WEST SUSSEX COUNTY COUNCIL CONSULTATION

TO:	Arun District Council FAO: Hannah Kersley
FROM:	WSSC – Highway Authority
DATE:	23 February 2026
LOCATION:	Southern Allotments Hampton Park Littlehampton
SUBJECT:	LU/263/25/RES Approval of reserved matters (access, appearance, landscaping, layout and scale) following the approval of LU/47/11/ for Southern Allotments. Amendment to the above application dated 10th February 2026 relating to updated Vehicle Swept Path Analysis
DATE OF SITE VISIT:	n/a (desktop study undertaken – site visited previously)
RECOMMENDATION:	No objection/advice

This is the second WSSC Highways response to the above planning application seeking approval of reserved matters (access, appearance, landscaping, layout and scale) following the approval of LU/47/11/ for Southern Allotments.

Drawing Status	Draft		
Client	Persimmon Homes Thames Valley		
Project	Littlehampton Allotments		
Drawing Title	Vehicle Swept Path Analysis 2		
Scale	As Shown	Date	Apr 23
Drawn By	SMO	Checked By	EJD
Drawing No.	2021-6309-102		Rev.
		B

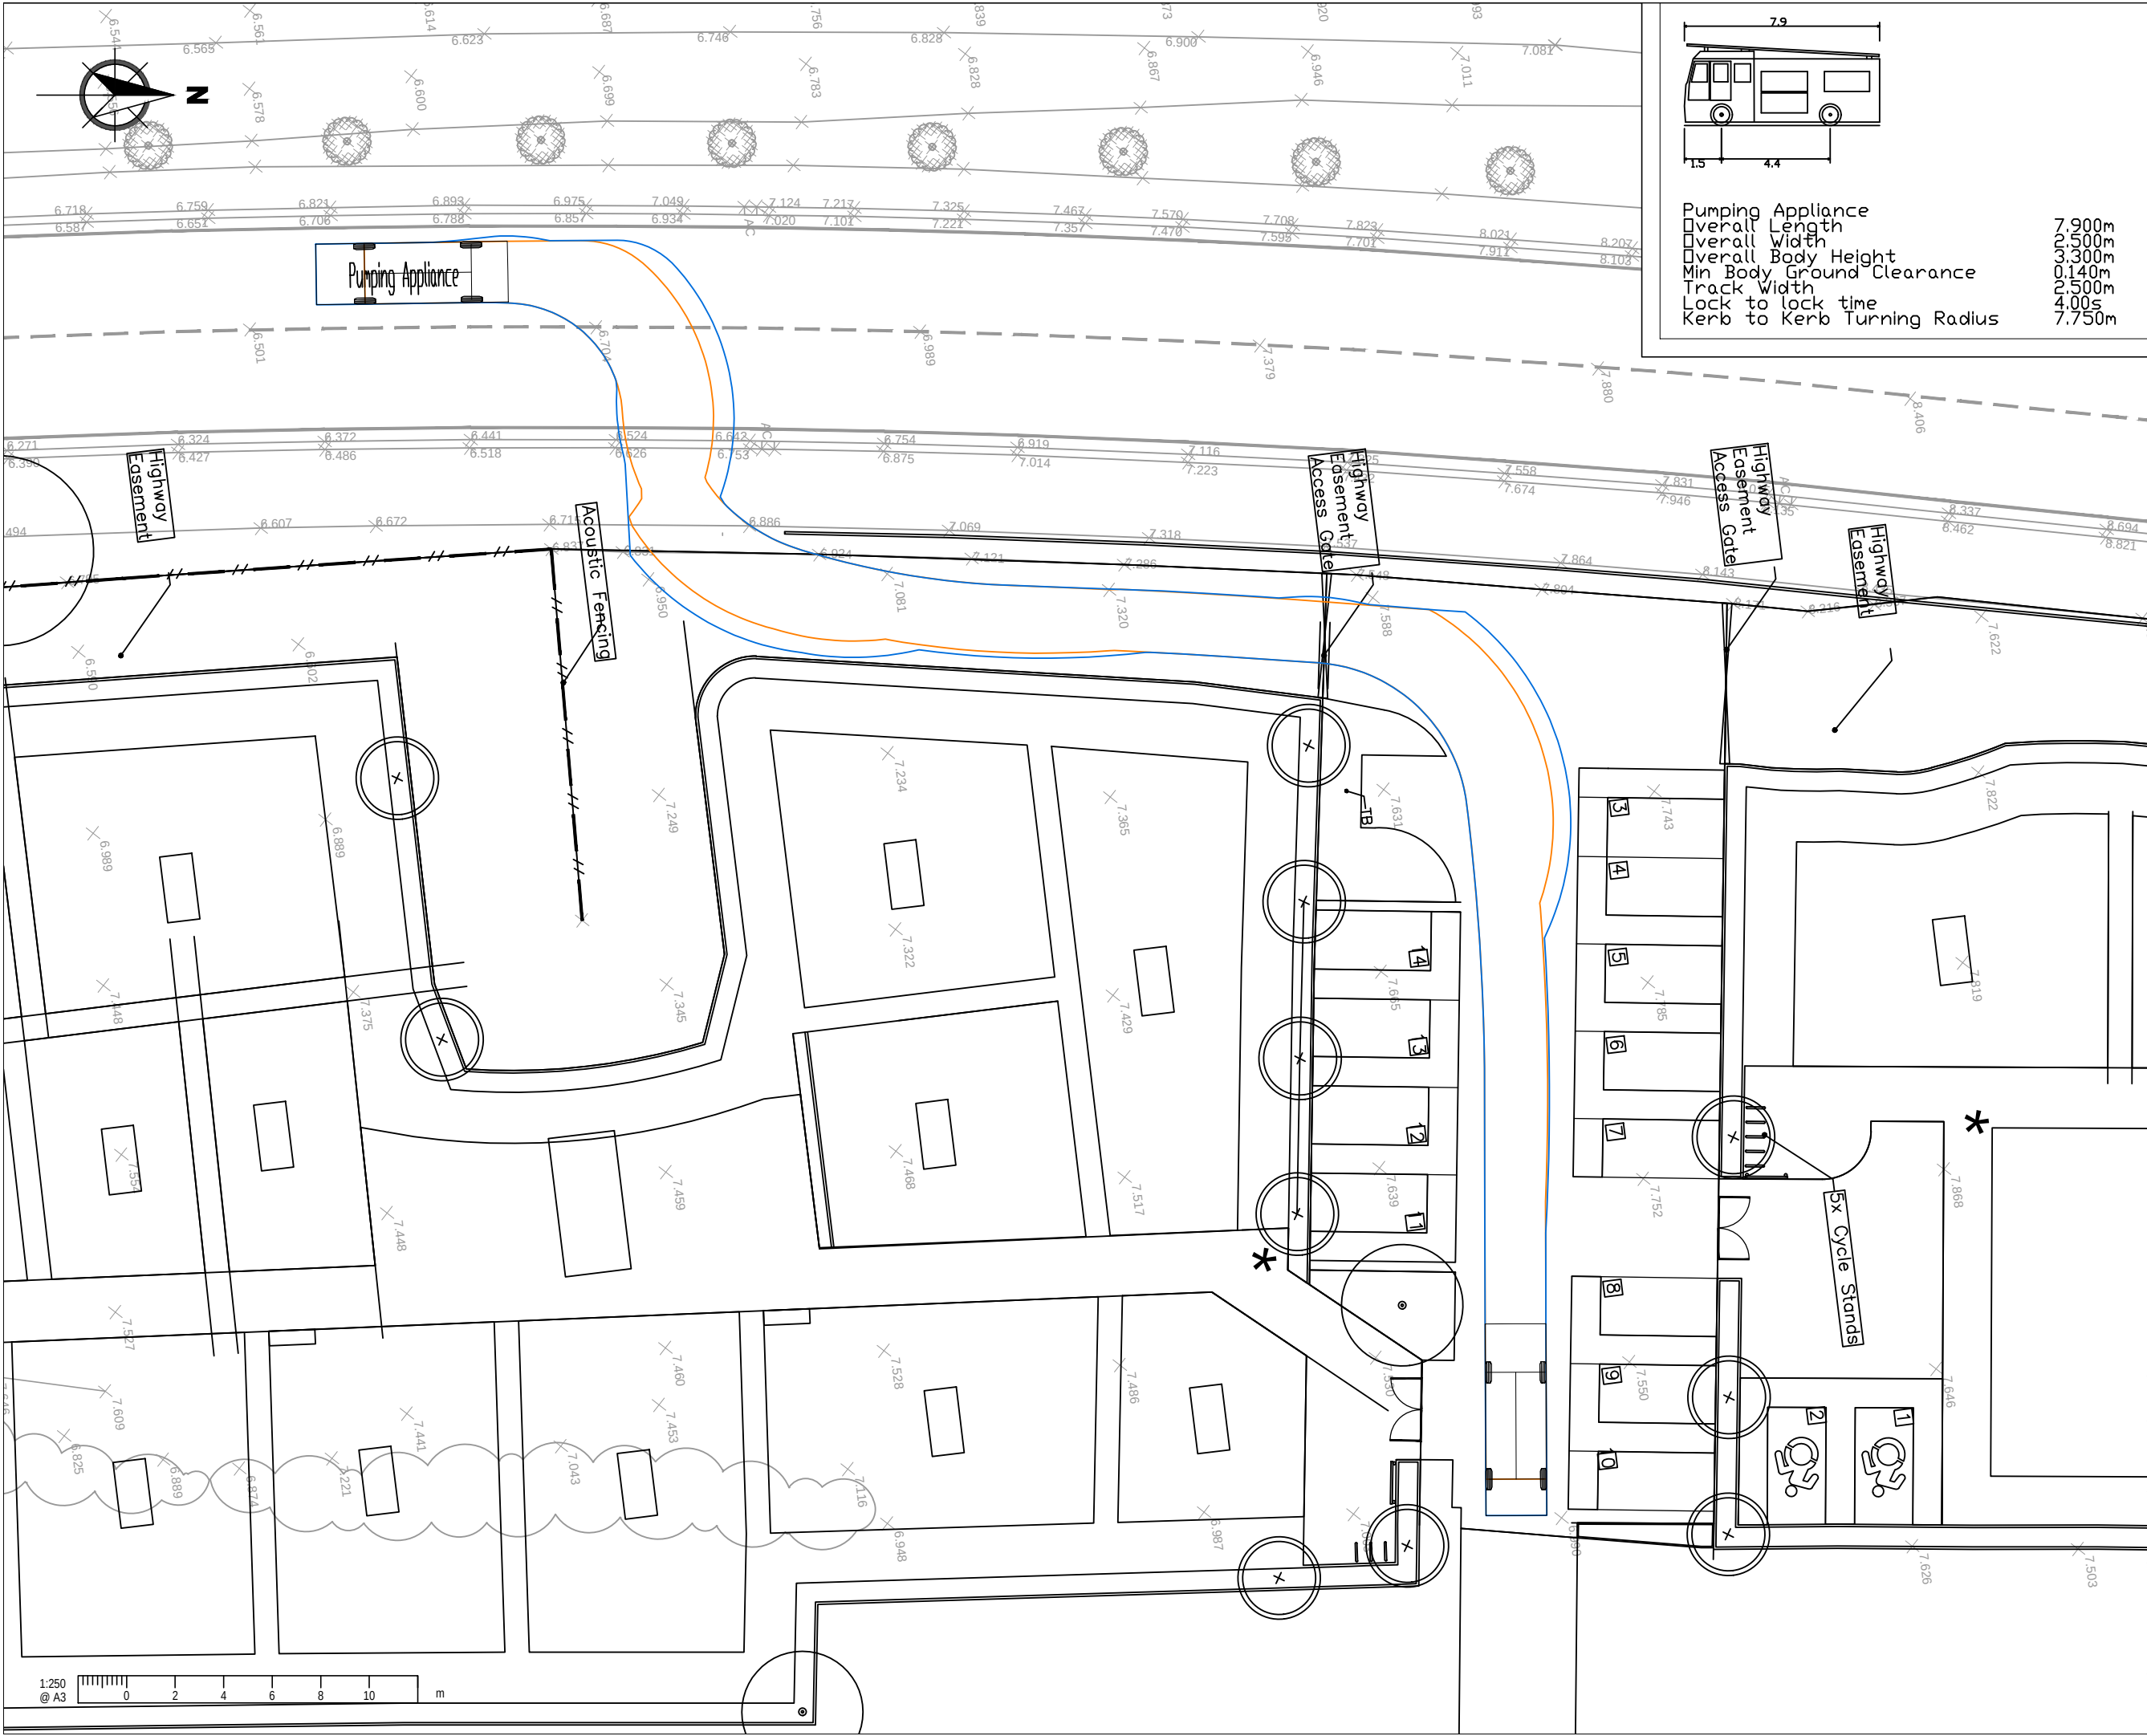
However, given that the different lengths were raised, the applicant was asked to provide additional tracking through the site for the vehicle lengths set out above.

Following sight and review of updated tracking drawing 2021-6309-102 revision 'C', the applicant has demonstrated that the largest vehicle referred to above should be able to drive through the site from Nightingale Way through to Holly Drive.

Access Overview and Visibility Splays

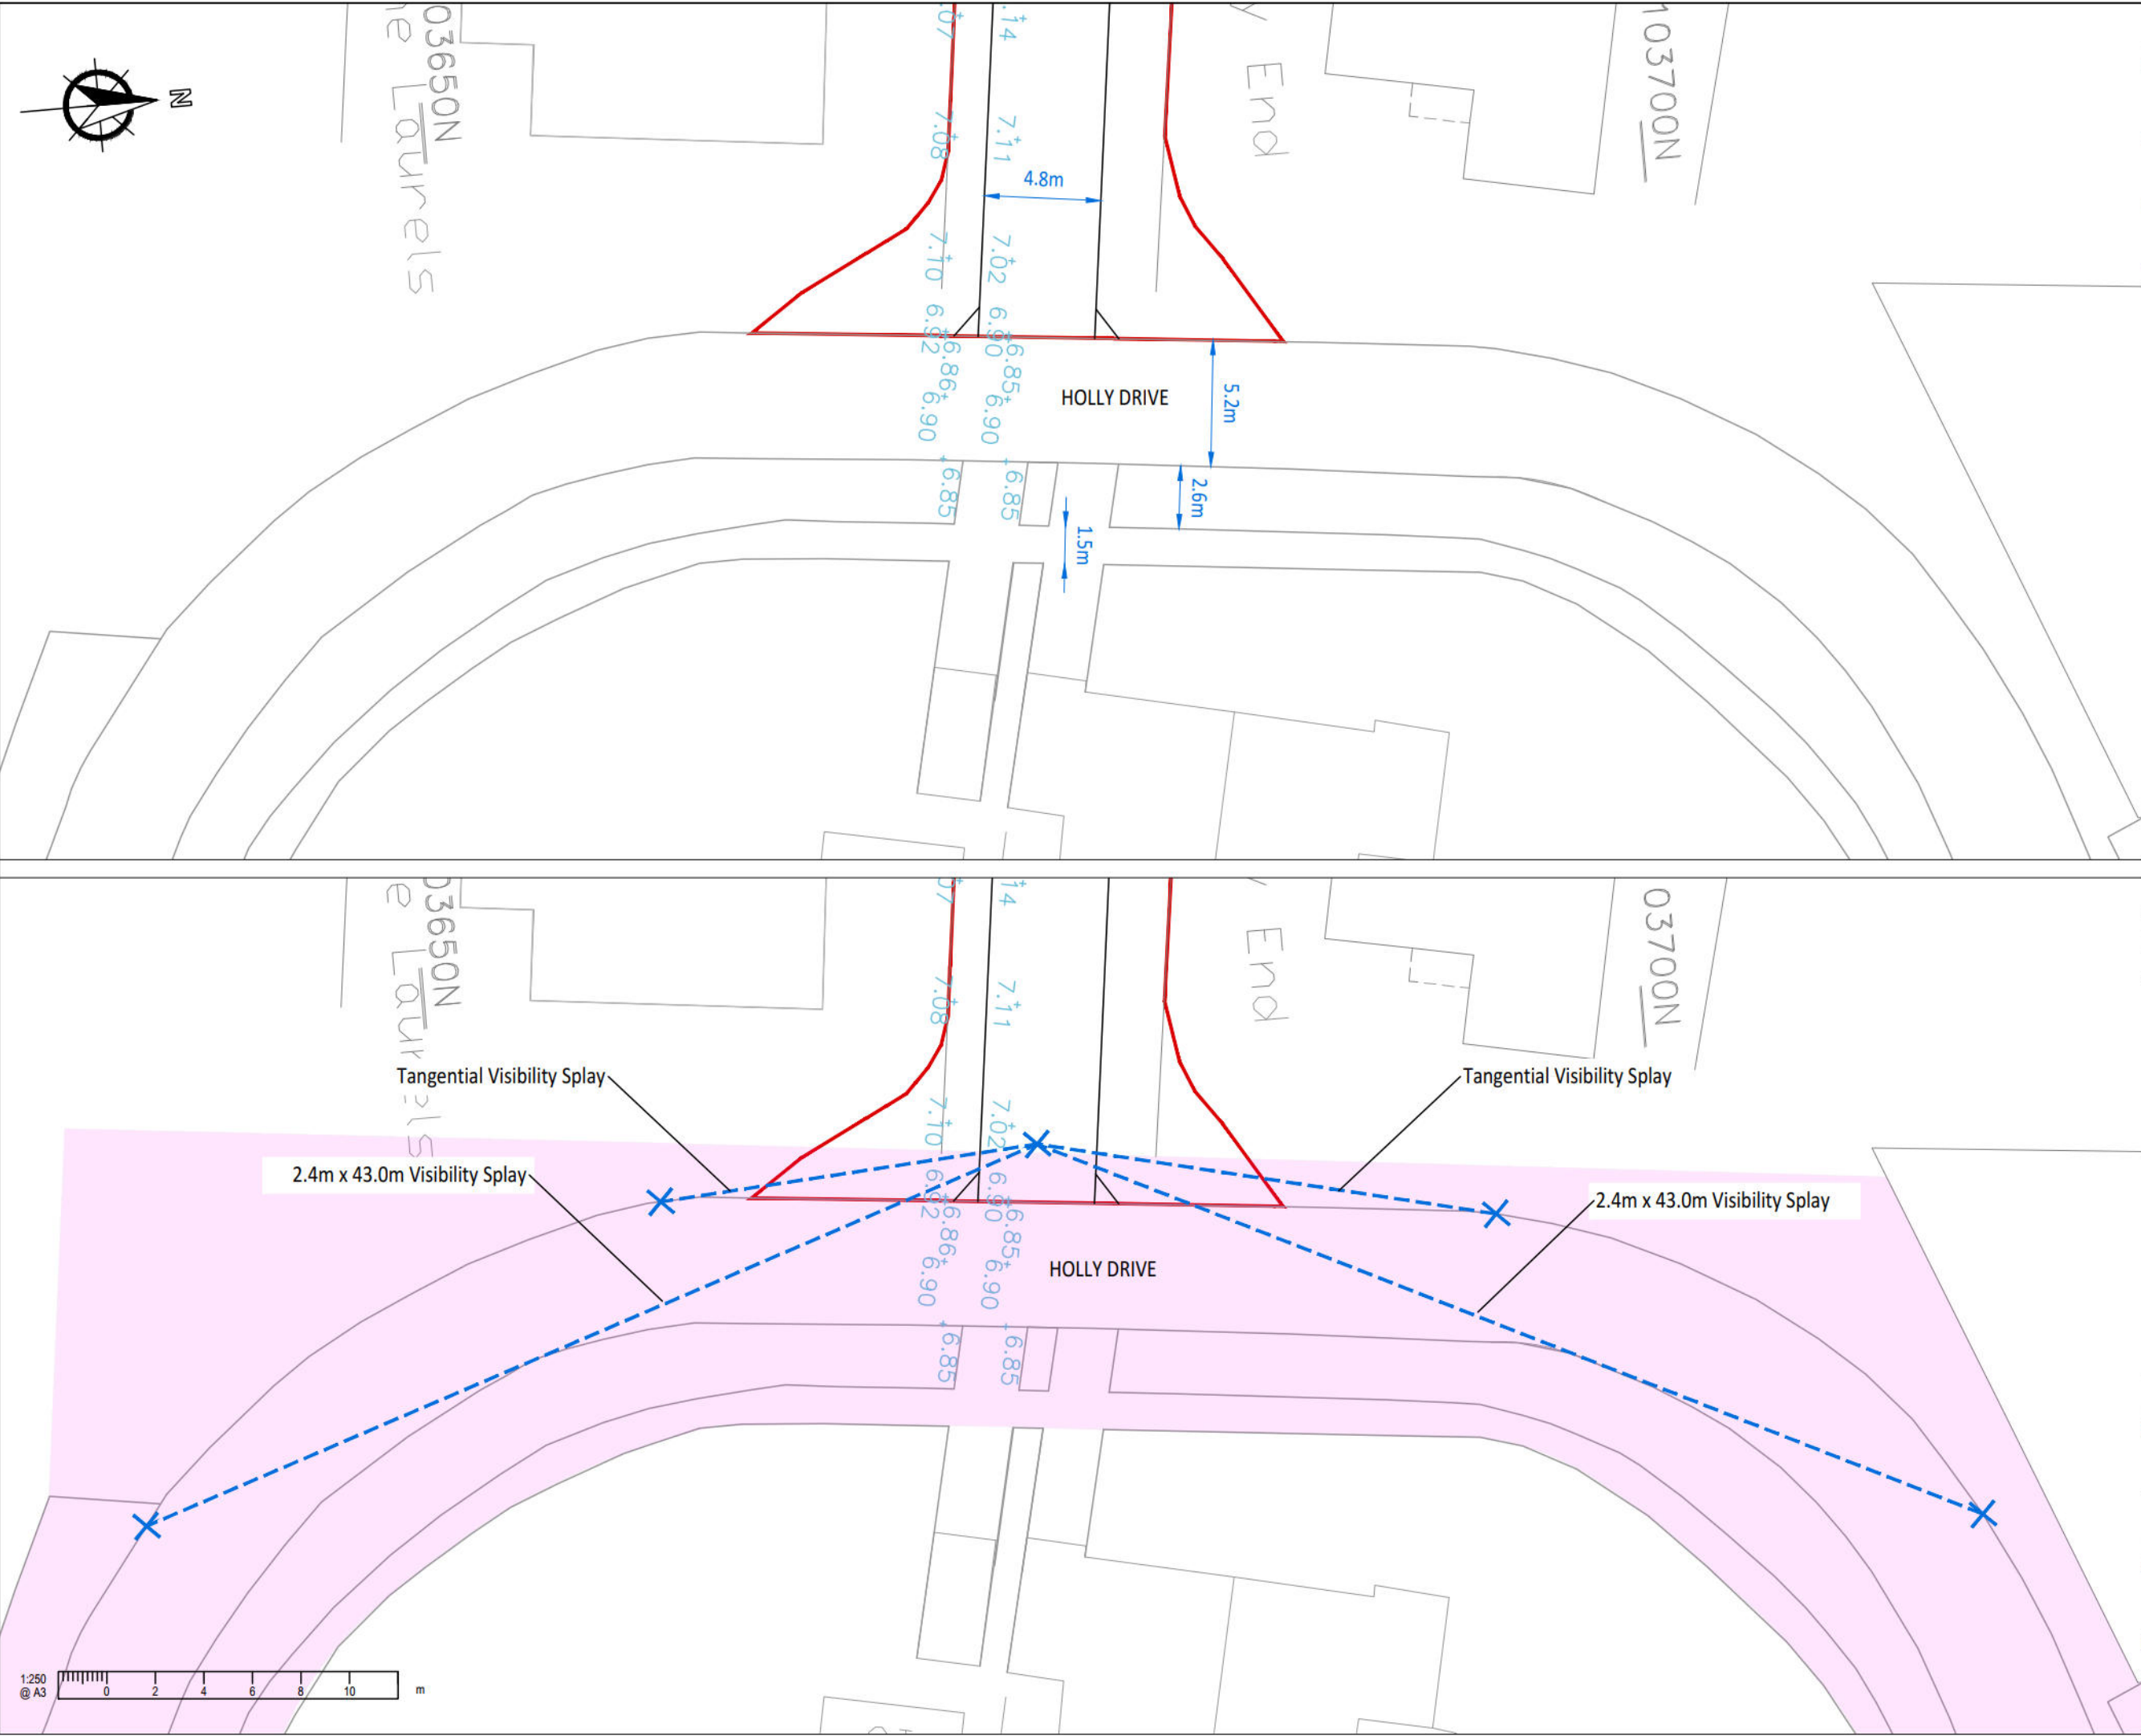
No part of the development shall be first occupied until visibility splays of 2.4 metres by 43 metres have been provided at the proposed site vehicular access onto Holly Drive in accordance with the approved planning drawings. Once provided the splays shall thereafter be maintained and kept free of all obstructions over a height of 0.6 metre above adjoining carriageway level or as otherwise agreed.
